Planning Application Ref: FG/27/18/PL

Location: 58 Ferringham Lane, Ferring

Description of works: Demolition of existing care home & redevelopment to provide for apartment building for 7 self-contained flats with cycle store, bin storage and car parking.

Comments On Application:

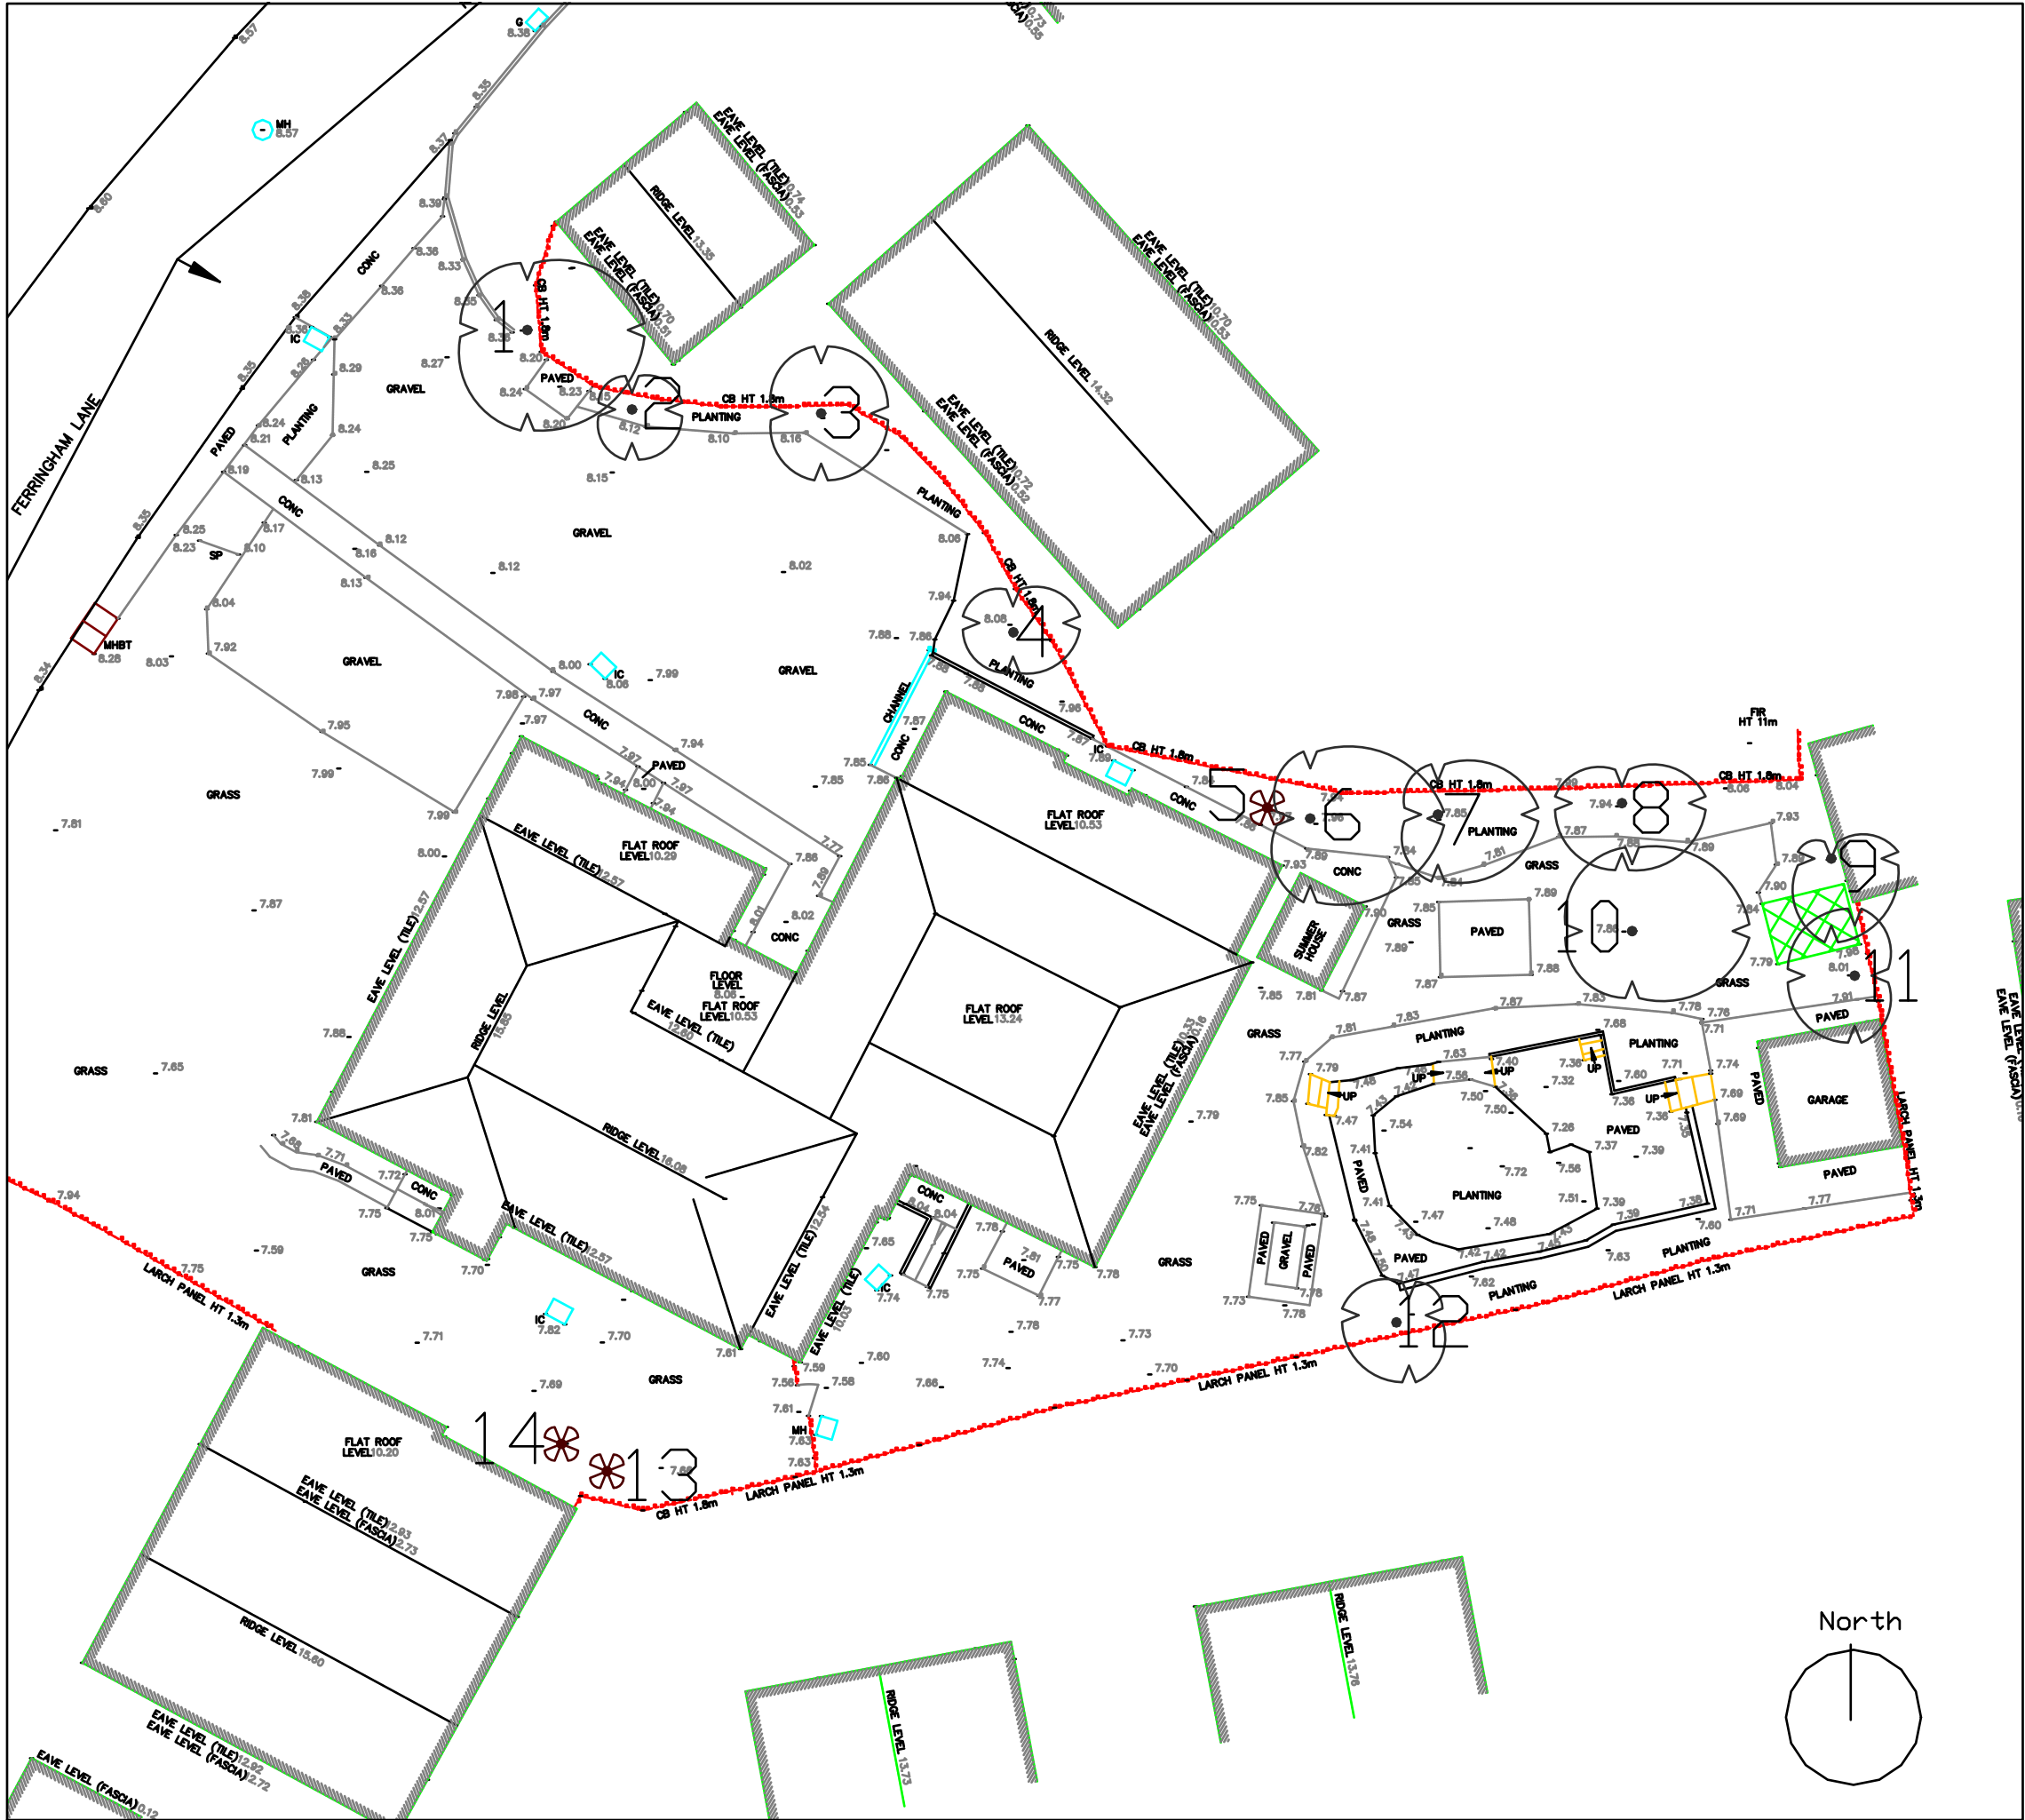
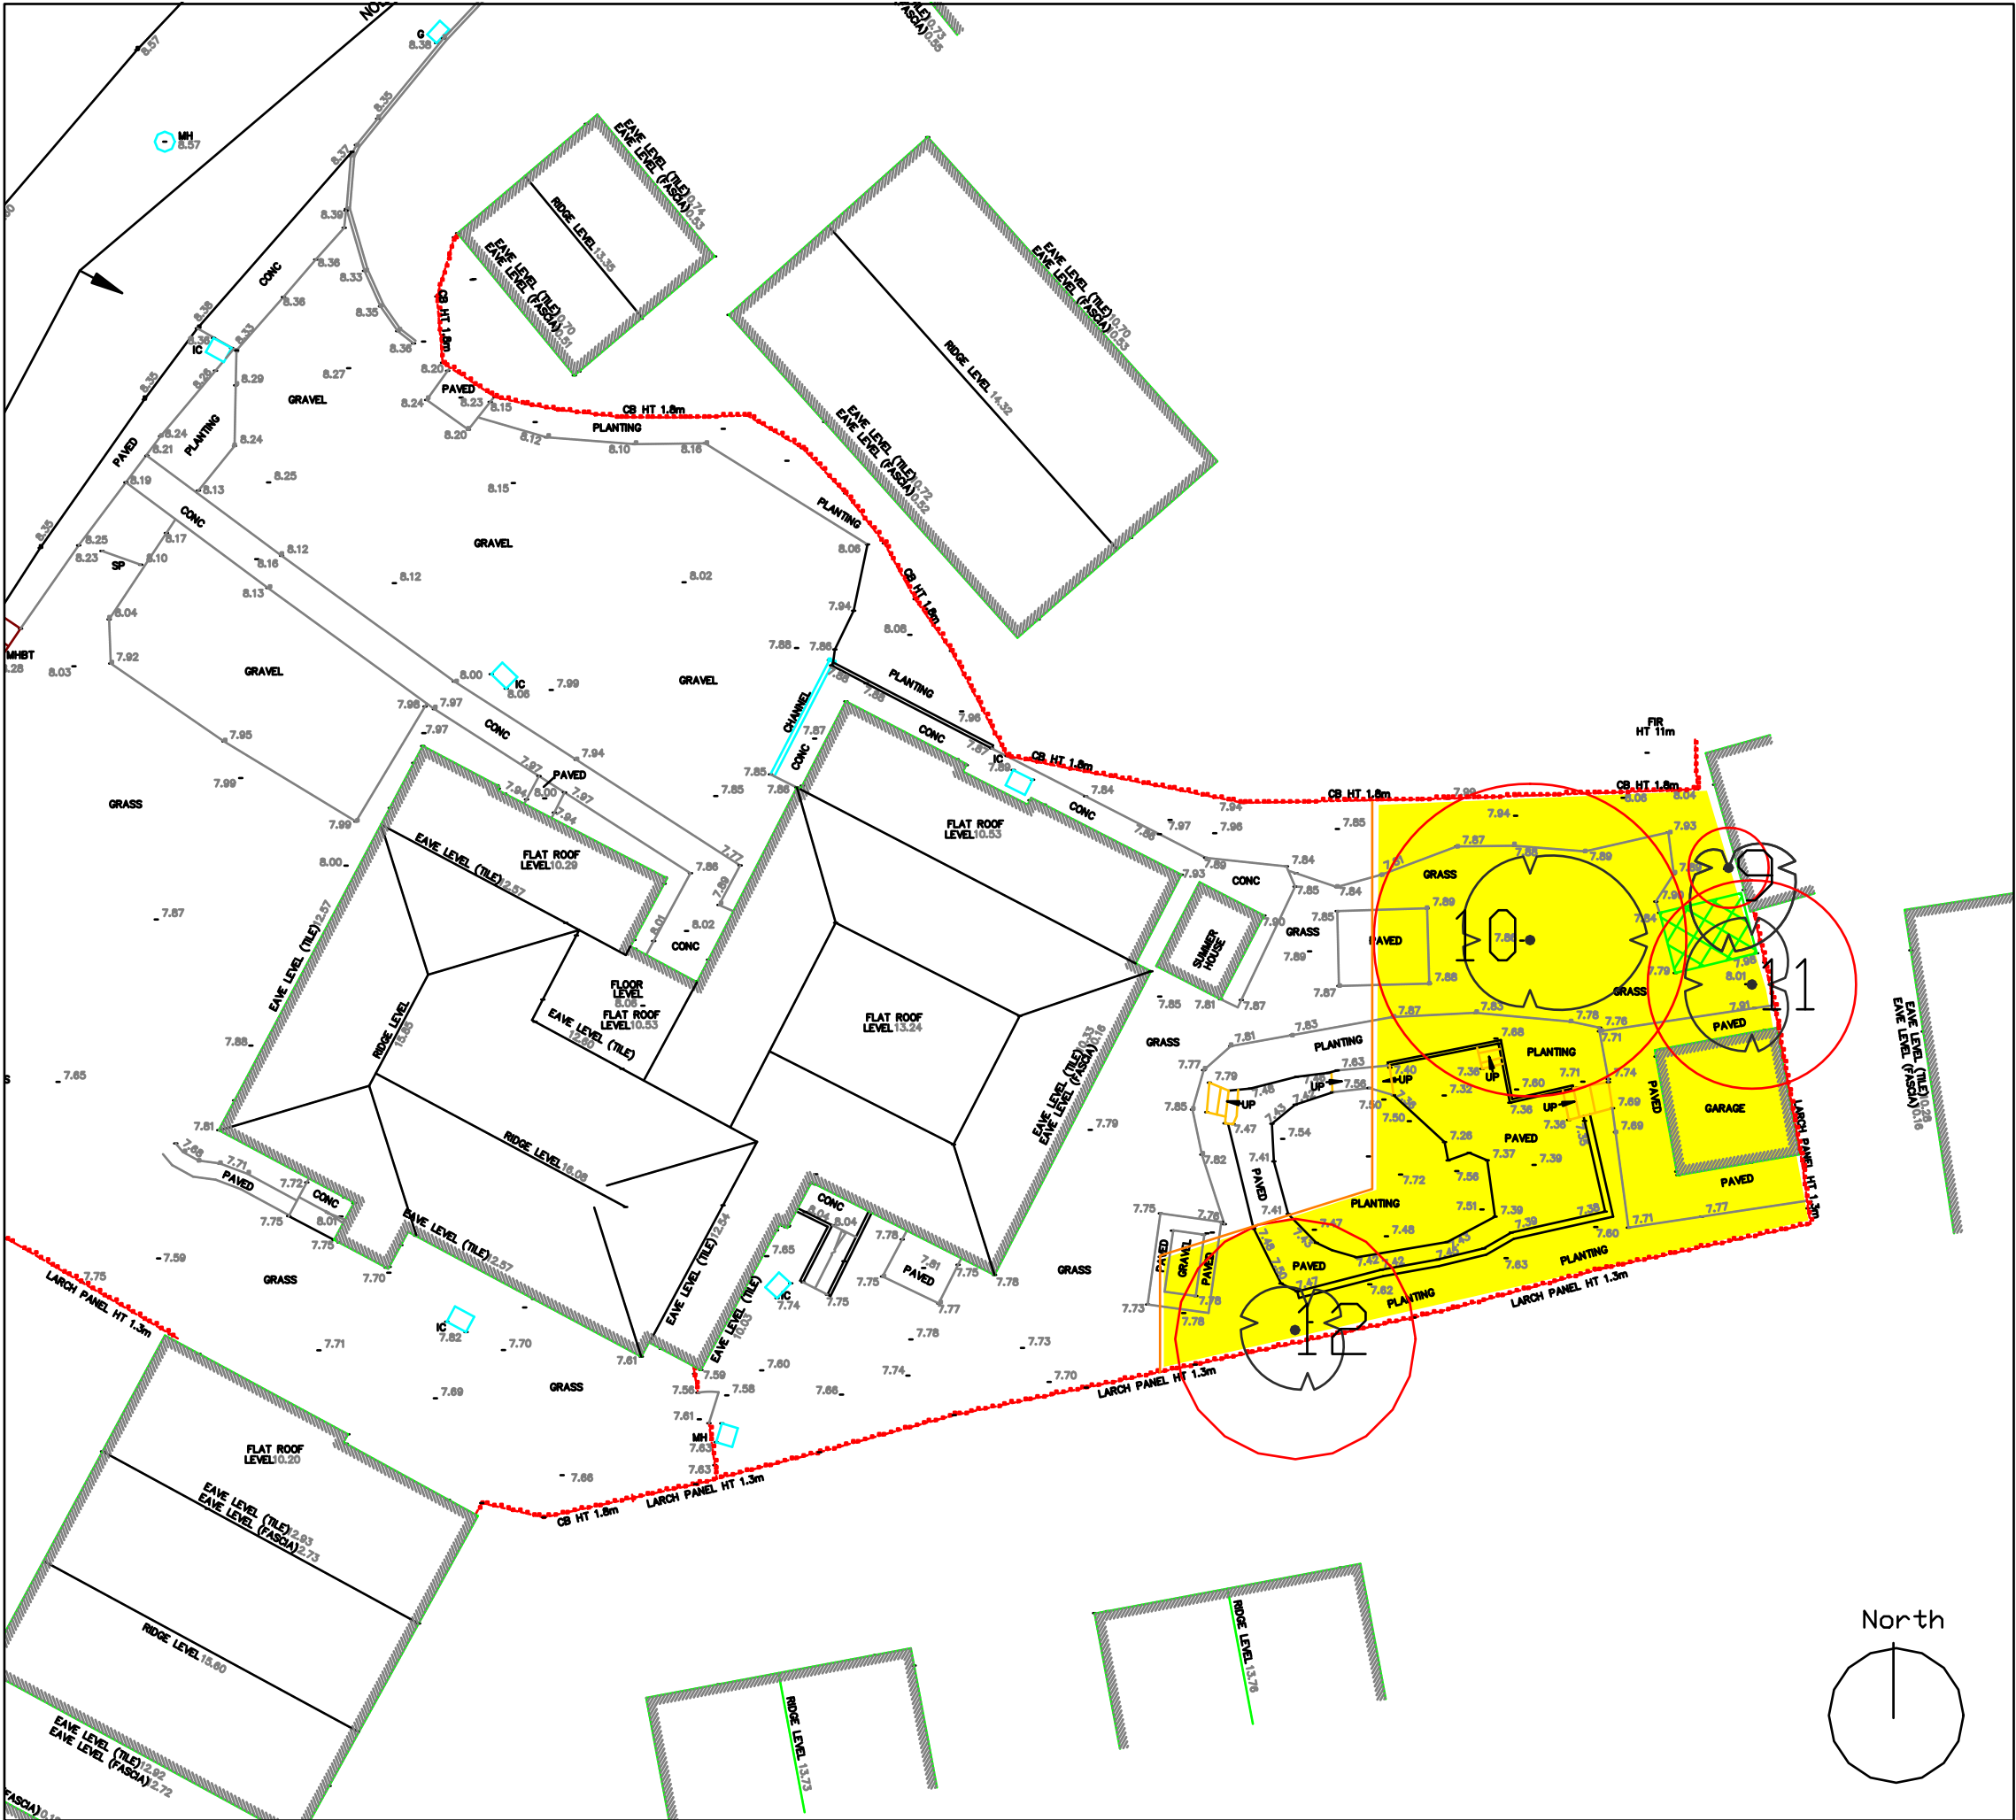
- This application has been supported by a Method Statement Report & Tree Protection Plan prepared and submitted by **Nicholas Jones Consultants Ltd.**
- It concludes that there are 14 trees on this site that are all of low value and poor condition 11 meriting only a **C** grading and 3 are fell graded **U** – I agree with this statement.
- **The Tree Protection Plan Ref: NJCL 214 B-1 – 22.01.2018** shows that only trees 9; 10; 11 and 12 will be retained and protective fencing will be erected to seal this Construction Exclusion Zone for the duration of the main build process – I would support this approach.

- I register **NO OBJECTION** to this application but would wish to see the following standard Condition applied to the approval:-
1. All demolition & construction works are to be carried out in strict accordance with :- **Arboricultural Method Statement Report Ref: NJCL 214 and Tree Protection Plan ref: NJCL 214 B-1 – 22.01.2018**

- A **PRE-COMMENCEMENT Site Meeting** is to take place between the Arun DC Tree Officer and the Arboricultural Consultant representing the site owners – at this meeting all protective fencing will be inspected along with ground protection measures – they will be assessed to verify that they are ‘Fit for Purpose’ as required under British Standard 5837:2012 and have been erected and positioned exactly as shown on the **Tree Protection Plan Ref: NJCL 214 B-1 – 22.01.2018**
